Subject: LU/88/22/PL

LU/88/22/PL

Mewsbrook House Care Home 59-61 Street Littlehampton BN17 6AU

Installation of a second floor in the form of a mansard roof on the rear wing of the existing care home, replacement windows in the original wing of the property and the reconfiguration of a 9 No. bedrooms on the first floor to 7 No. larger bedrooms.

LEFT – South Elevation (Existing – UPVC Windows)

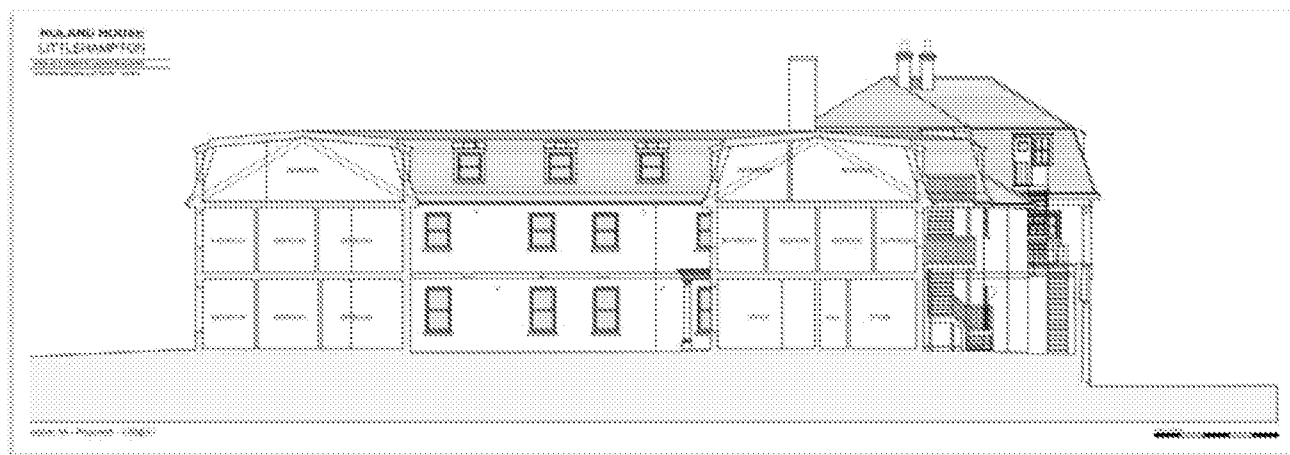
The DAS/heritage statement indicates that the existing inappropriate UPVC windows in the oldest part of the building (i.e. non C.20 element) will be replaced with sash windows to match the originals. This is a positive element of the proposals and represents conservation gain. This element can be supported as a positive approach, subject to further information regarding their detailed design and appearance (including glazing bar and glazing system details).
